AA.23.33.03 Immingham Green Energy Terminal, ExA Questions

Prepared for: Becky Garrett
 Prepared by: Harry Robinson (SYSTRA)
 Date: 12th March 2024
 Case Reference: DevHU0144
 Document Reference: DevHU0144 004 TM Final
 Reviewed/approved by: Terry Dale (SYSTRA)

Jacobs SYSTRA Joint Venture [JSJV], on behalf of National Highways, has reviewed the following Written Questions [WQ1] from the Examining Authority [ExA] within **Table 1**;

FIGURE TITLE
Cumulative Assessment Short List - Sheet 2 of 2

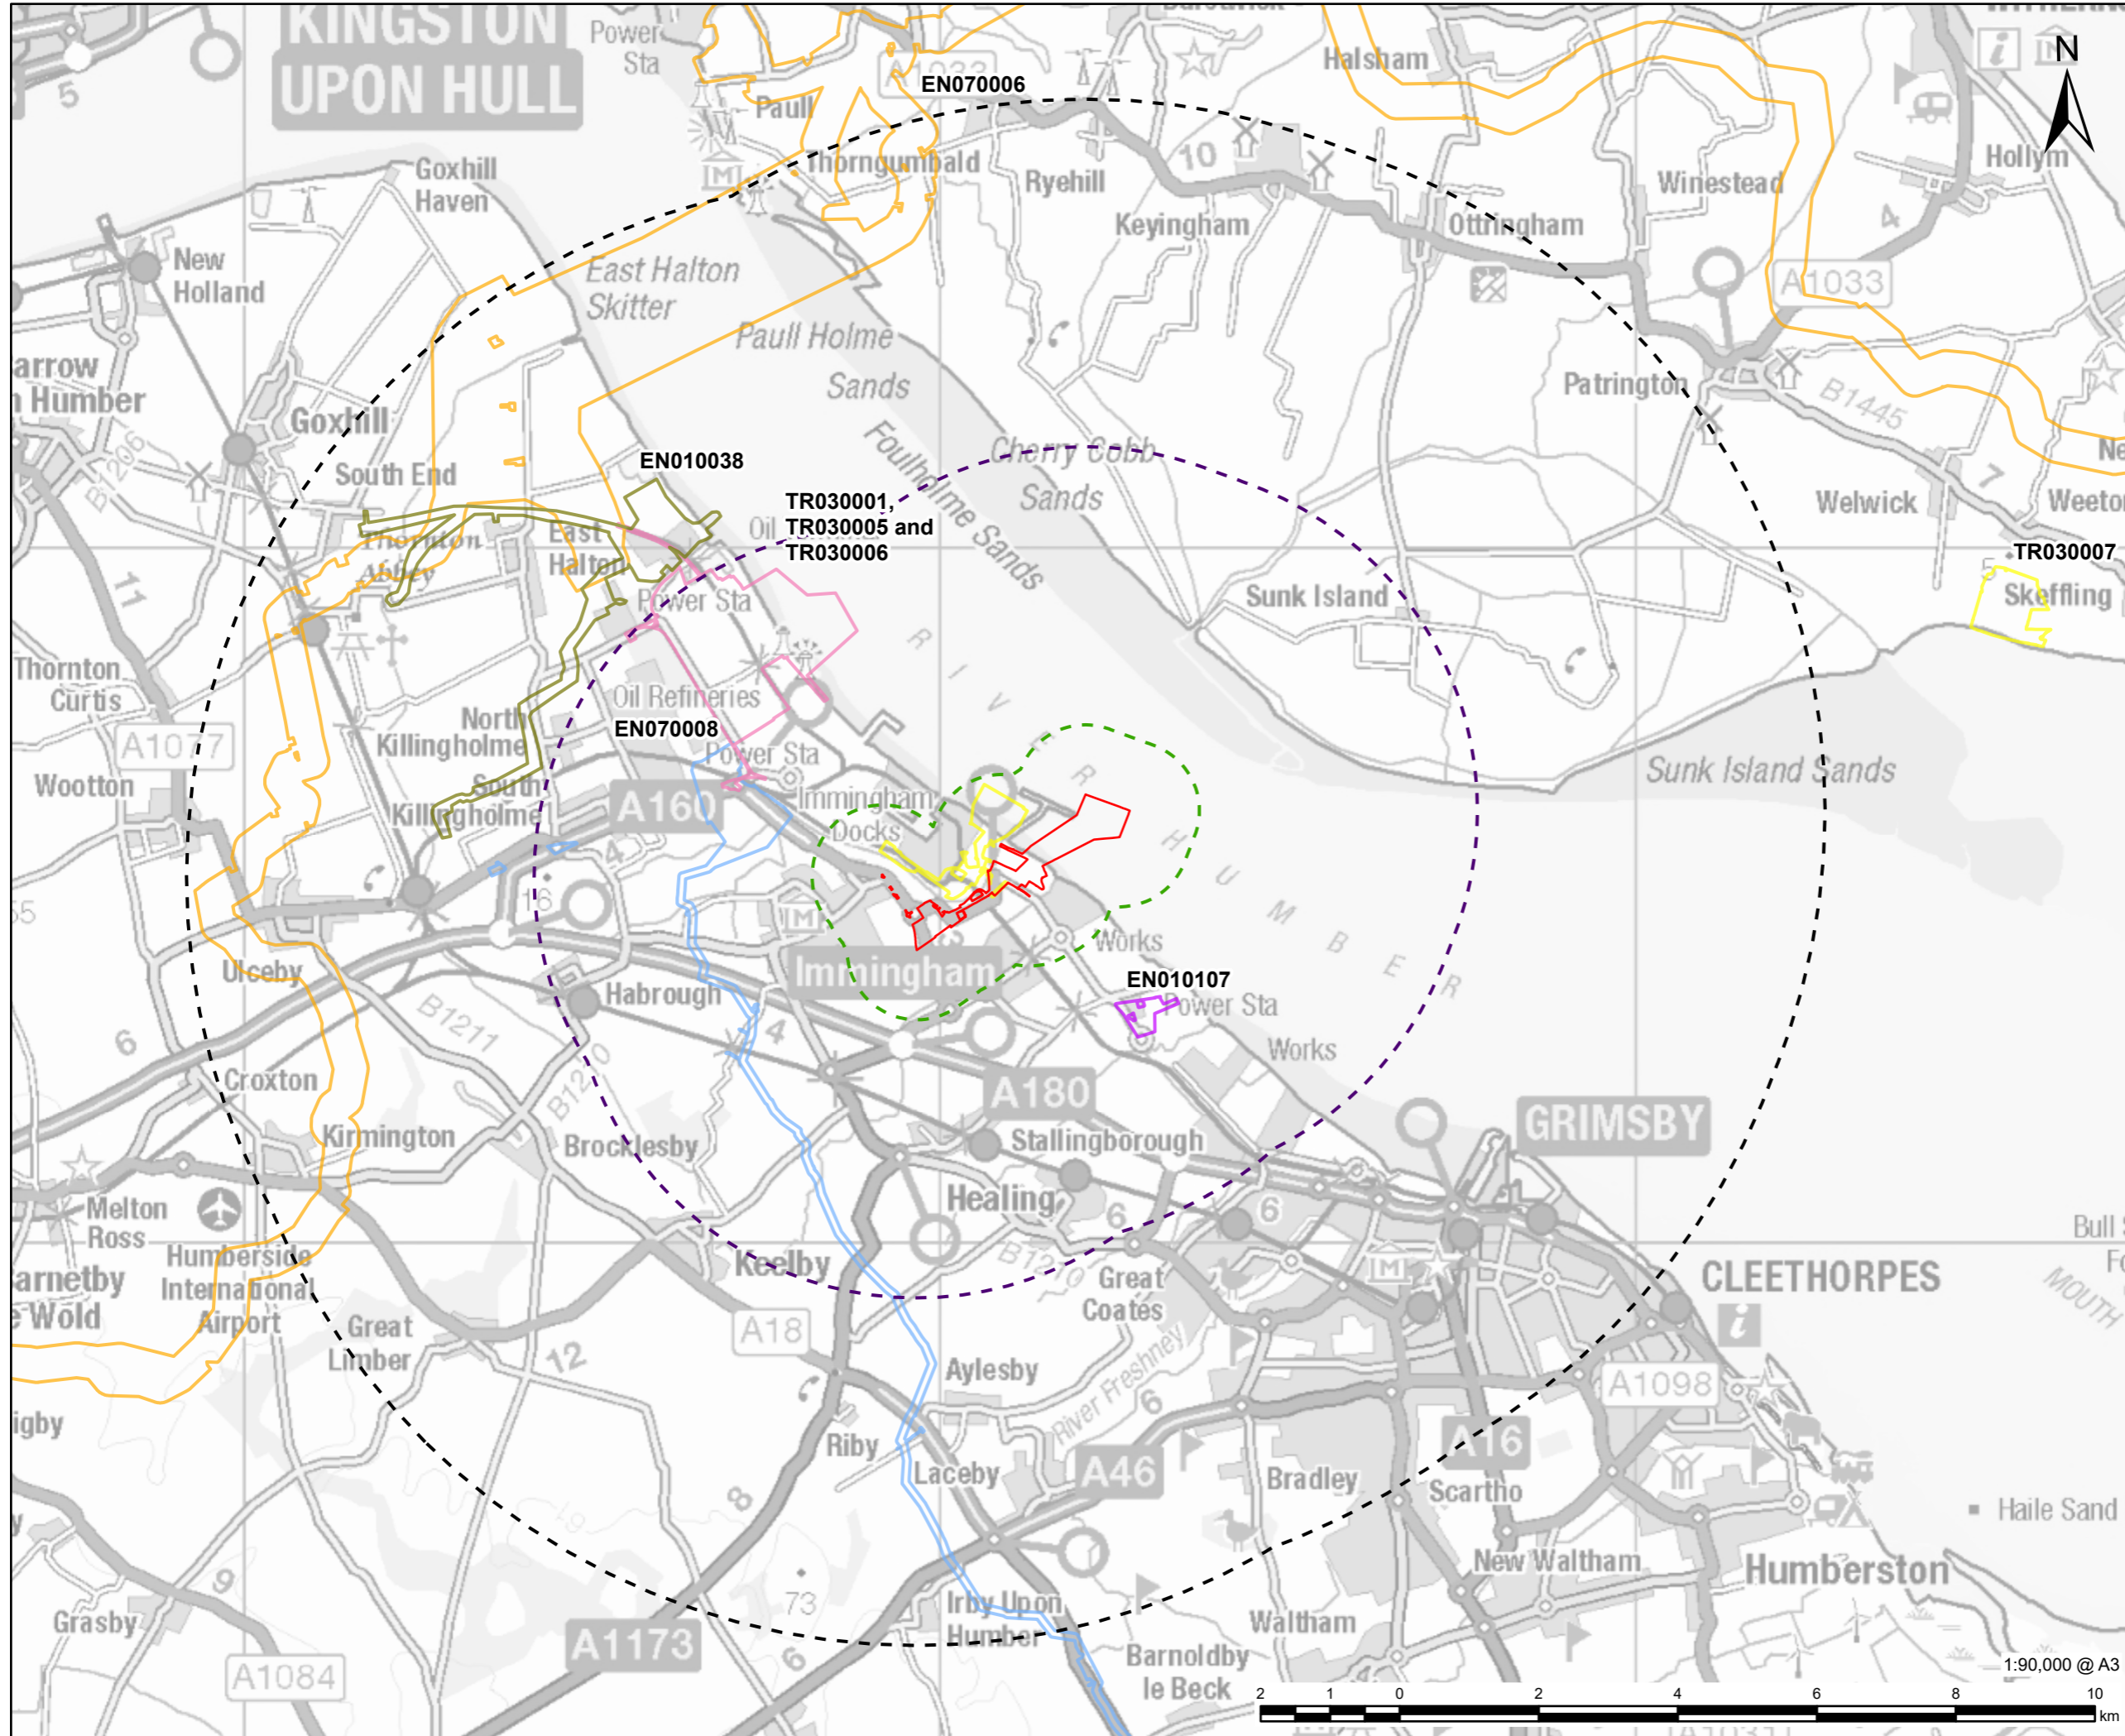
<p>87 two-way trips between 08:00-09:00 and 17:00-18:00. Consequently, we have recommended the distribution of the 87 two-way vehicle trips on to the network are presented, in order to show the anticipated impact of vehicle trips on the SRN.</p> <p>Consequently, the severity of the increase in traffic will be established once the additional information is provided.</p>
Q1.16.1.2	<p>Long and Short List of Projects Are you content that both the Cumulative Effects Assessment Long List [APP-218] and Cumulative Assessment Short List [APP-219] identifies all relevant projects and that the information contained within them is correct and up to date. If not, identify what additional information is required</p>	<p>We have reviewed the Cumulative Effects Assessment Long List [APP-218] and Cumulative Assessment Short List [APP-219] and cannot identify any additional information that is required at this time.</p>
